PLANNING CONSULTATION RESPONSE

Application No	2026/0431
Proposal	Prior Approval for electronic communications network. 20m High, Orion Slimline Streetworks Monopole hosting 6 no. antennas, 3 no. ERS, equipment housing and ancillary development.
Address	Northeast of Southgate, Shafton, Barnsley
Date of Consultation Reply	8 th July 2026
Consultee	Highways DC

Drawing Title	PROPOSED SITE PLAN
Purpose of Issue	PLANNING
Drawing Number	201
Surveyed By	SSB
Original Sheet Size	A3
Drawn	GJ
Date	18.02.26
Checked	PM
Date	18.02.26
Pack Issue	A
Issue	B

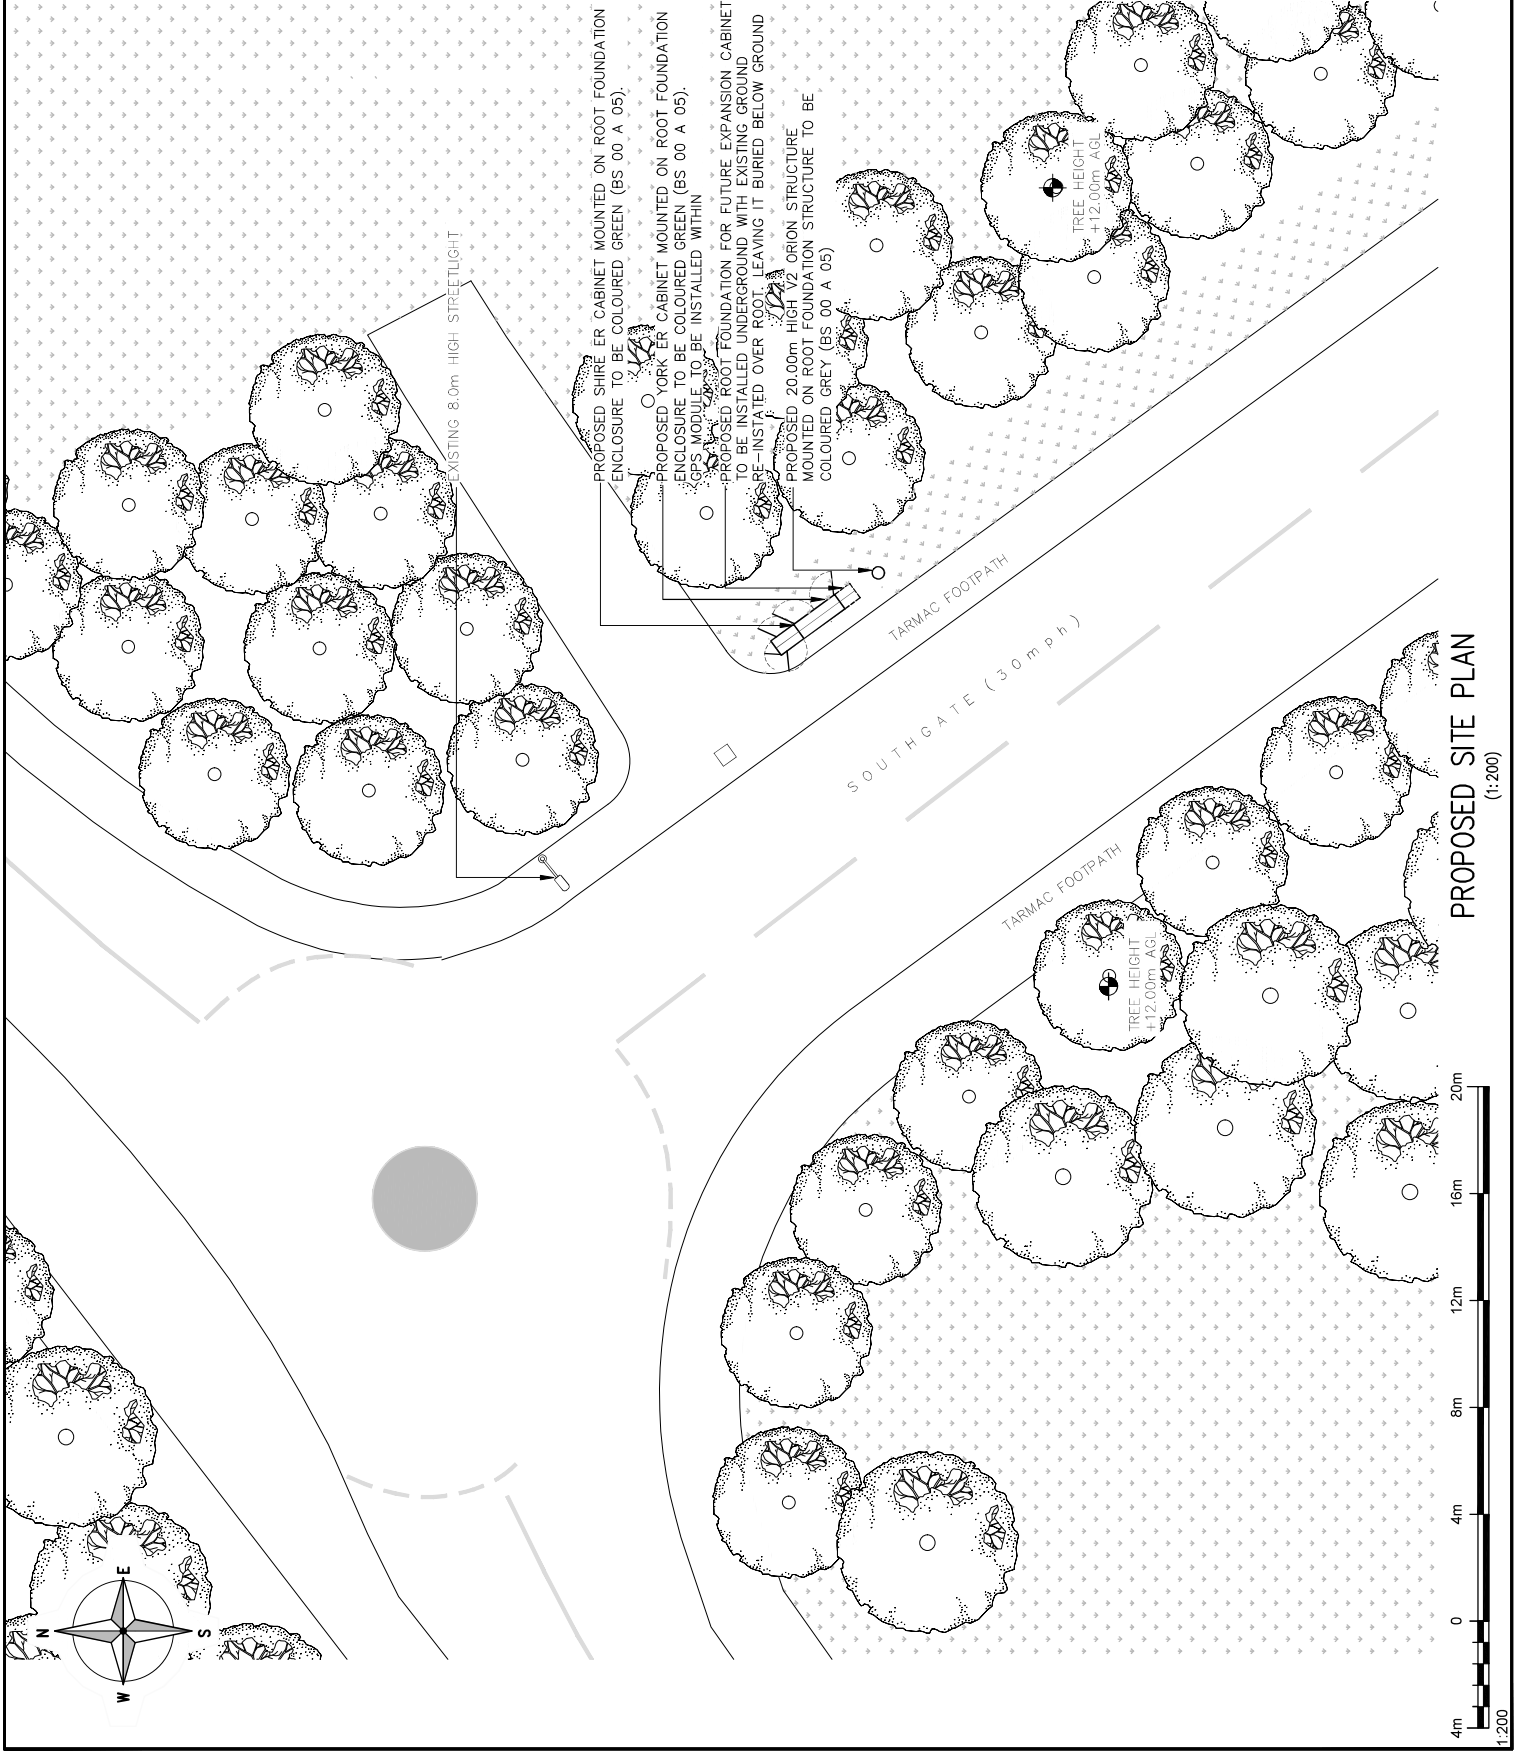
The submitted information indicates that it is proposed for an equipment cabinet to be erected immediately adjacent to a tarmac surfaced access off Southgate which leads to a field used for agricultural purposes.

This access is used by large farm machinery, as such, I am of the view that the cabinet in the proposed location would impede the access/egress of agricultural vehicles, to the detriment of highway safety.

It is suggested that the cabinet is repositioned to the other side of the proposed monopole structure (south-east along Southgate), in order for adequate access arrangements to be retained.
